From: [REDACTED]
To: [Norfolk Boreas](#)
Subject: Norfolk Boreas Project – EN010087
Date: 10 December 2019 20:26:25

My reference - 20022886

**SCENARIO 1**  
Figure: 29.25b (2 of 2)  
Viewpoint 3: Lodge Lane North

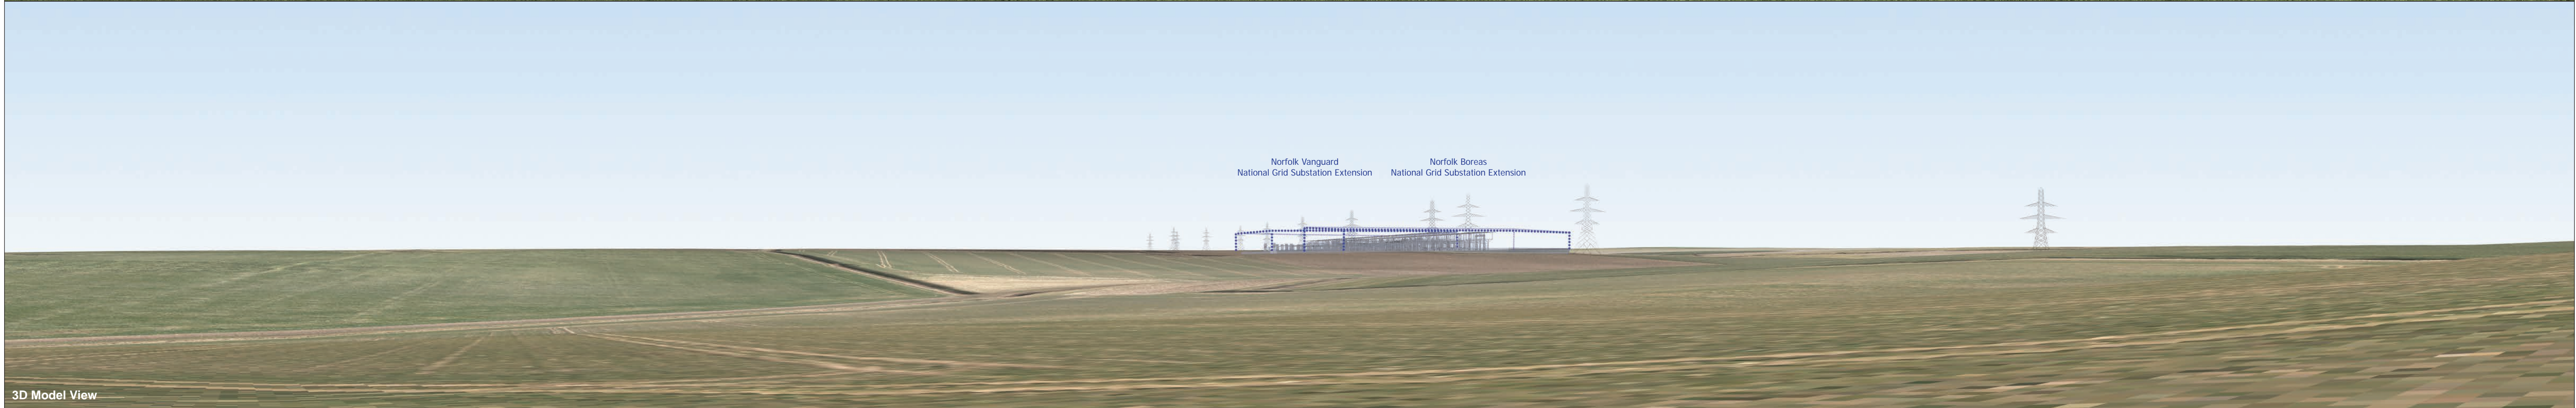
The photo montages of view point [3 Lodge Lane North](#) are flawed. Fig. 29.25b shows the problem. The baseline photograph shows the actual topography. The 3D model view shows the land's horizon, right to left, rising, and then falling forming a earth mound, concealing most of the converter halls. The actual baseline photograph shows the land gently falling away from the lane (right to left), with no mound. This is correct, as I am familiar with this view. Also the land does not fall away behind Lodge Farm, it is almost level, so in reality the view would show the halls almost in their entirety. (this affects scenario 1&2)
